HINCKLEY RAIL FREIGHT TERMINAL

Comments following 24 January 2024 Hearing

CPRE Leicestershire

February 2024

Appendix A Part 1 - General Arrangement Plan

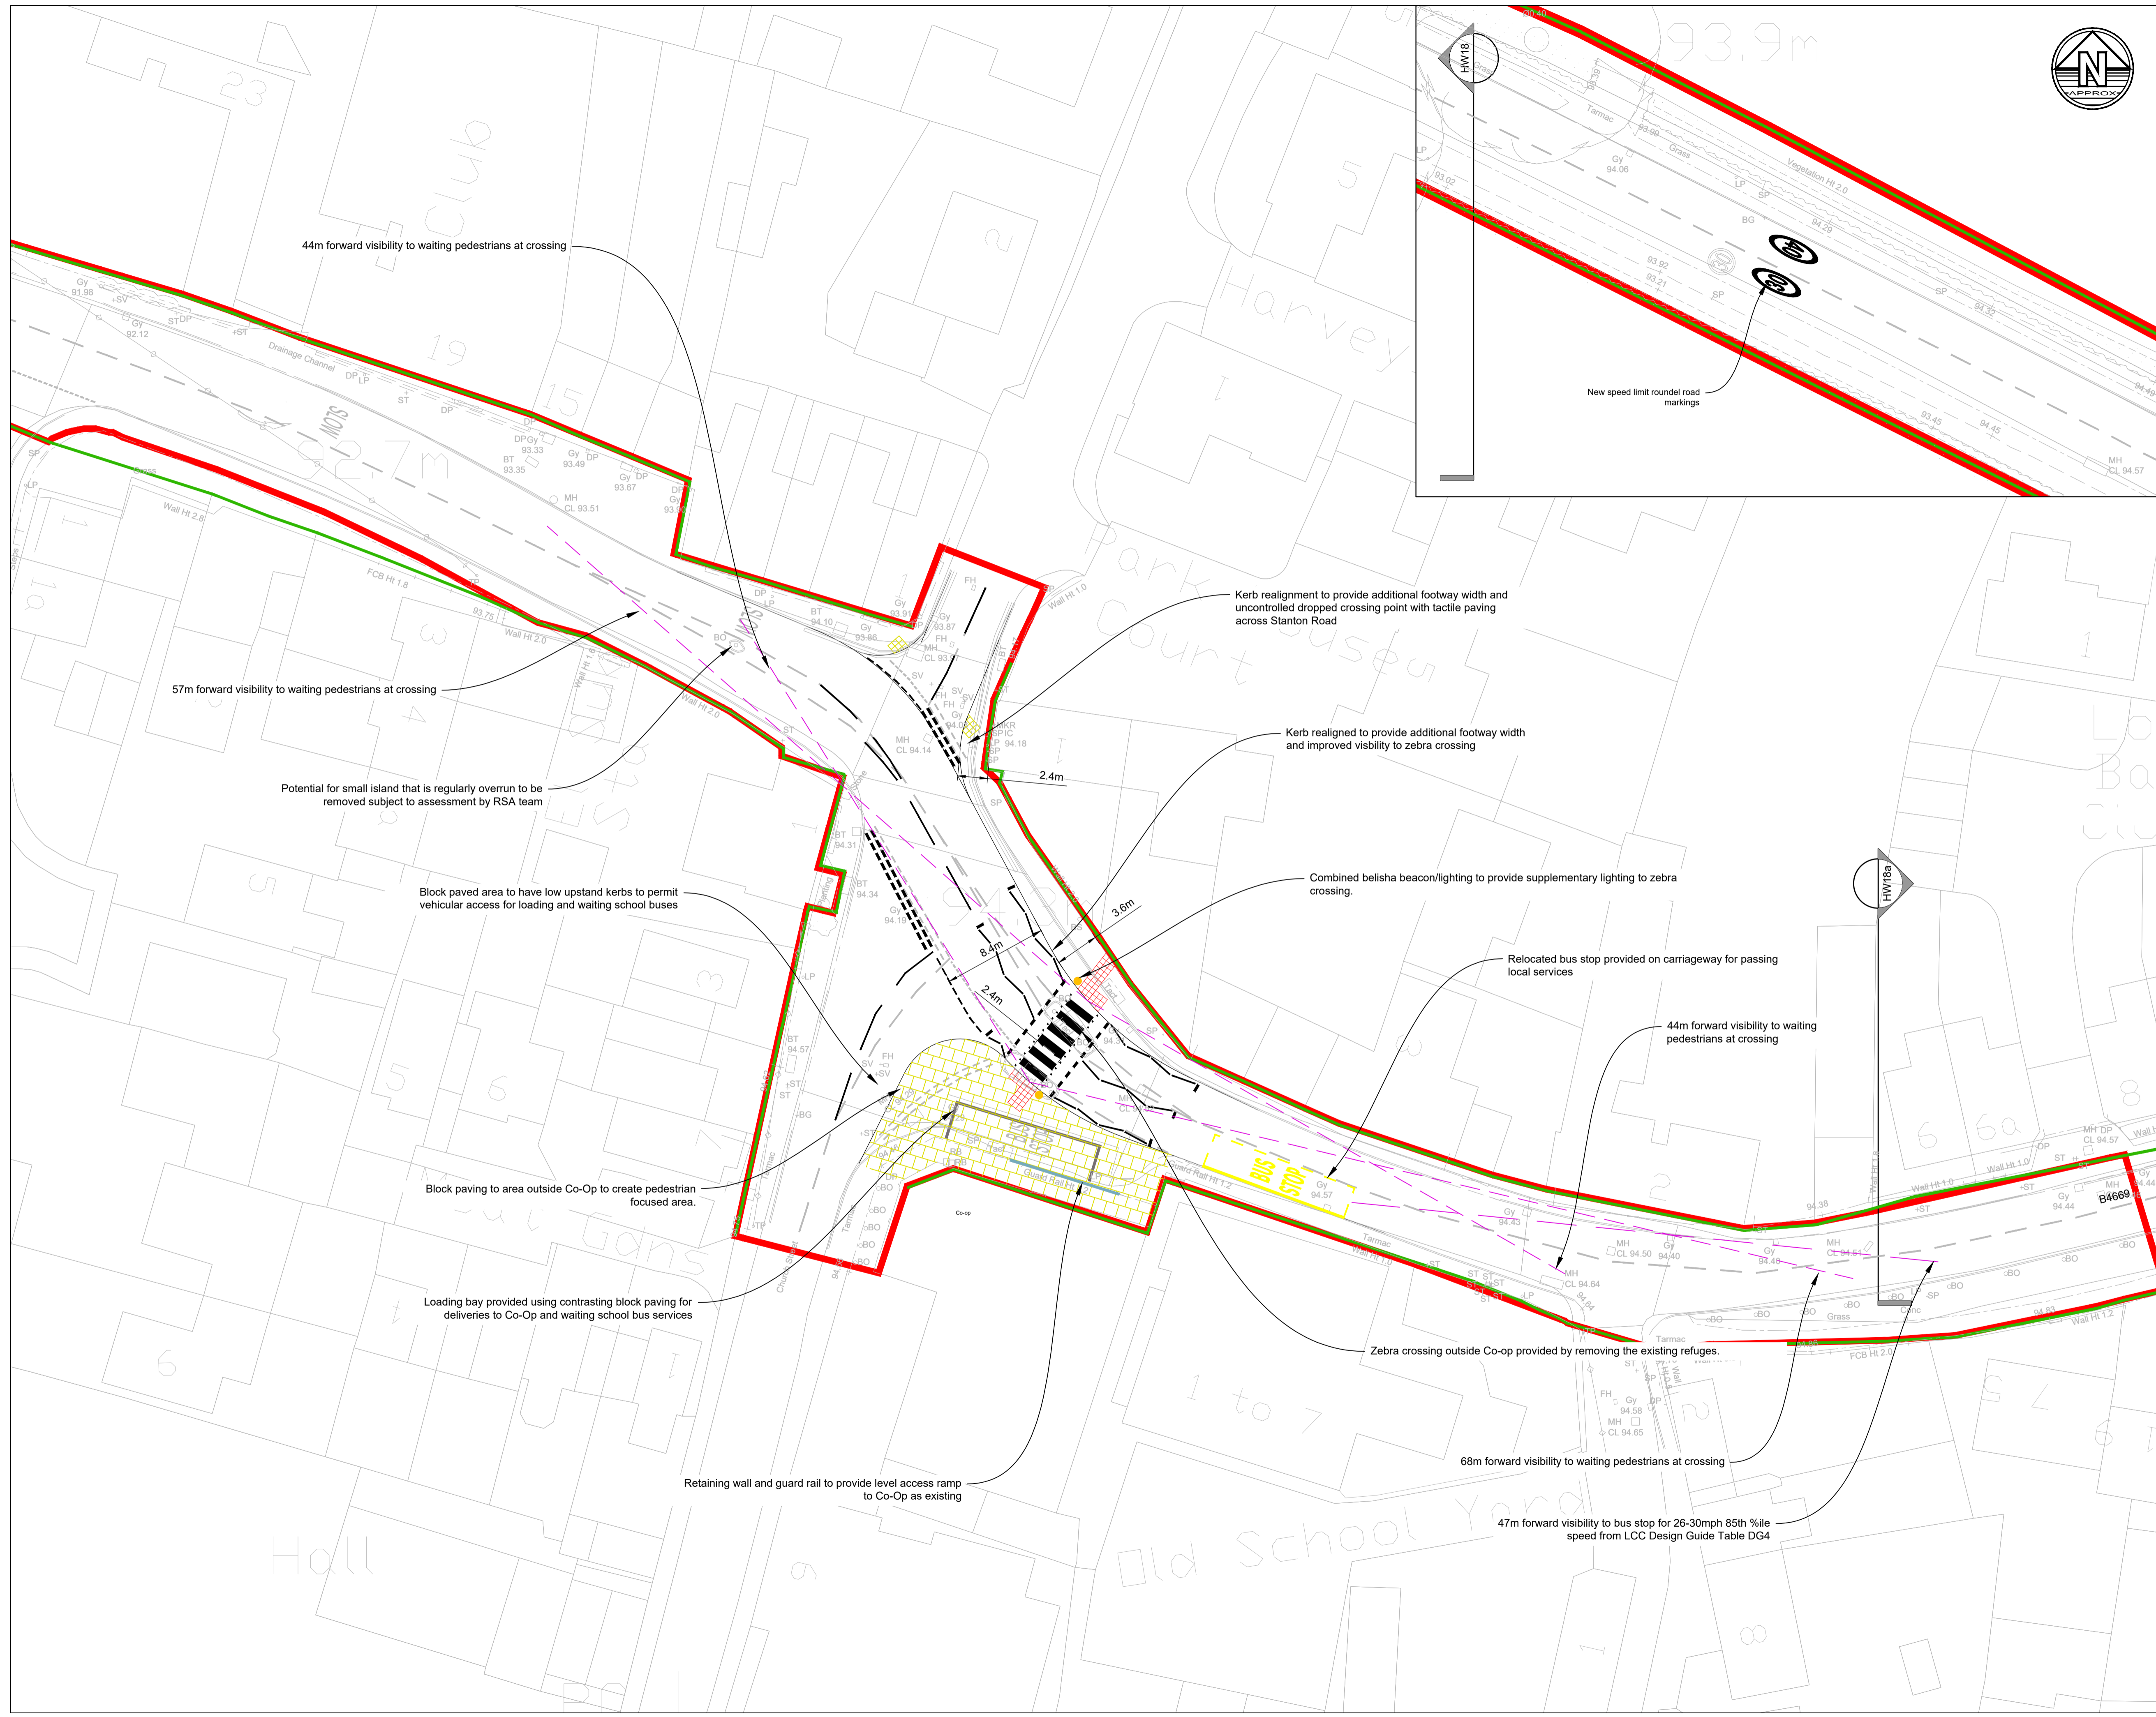
5.7 Having said that, we do agree with Para 3.3 of the RSA that the installation of a zebra crossing in Sapcote, where there is such limited visibility, risks pedestrians' behaviour being unsafe. That is not resolved by comments from Tritax.

5.8 We also agree with Para 3.4 that the narrow footway is an issue for the pedestrian crossing.

5.9 However, an even more obvious issue is the increase in pedestrian using that unsafe section of pavement to get to the centre of the village because of the relocation of the bus stop.

5.10 This would almost certainly increase the risk on a route which would carry additional HGVs due to the proposals, something not mentioned in the audit.

5.11 The relocation of the bus-stop is referred at by Tritax as a 'traffic calming' response, but this would be limited to the time when buses are stationary. It may be largely illusory.
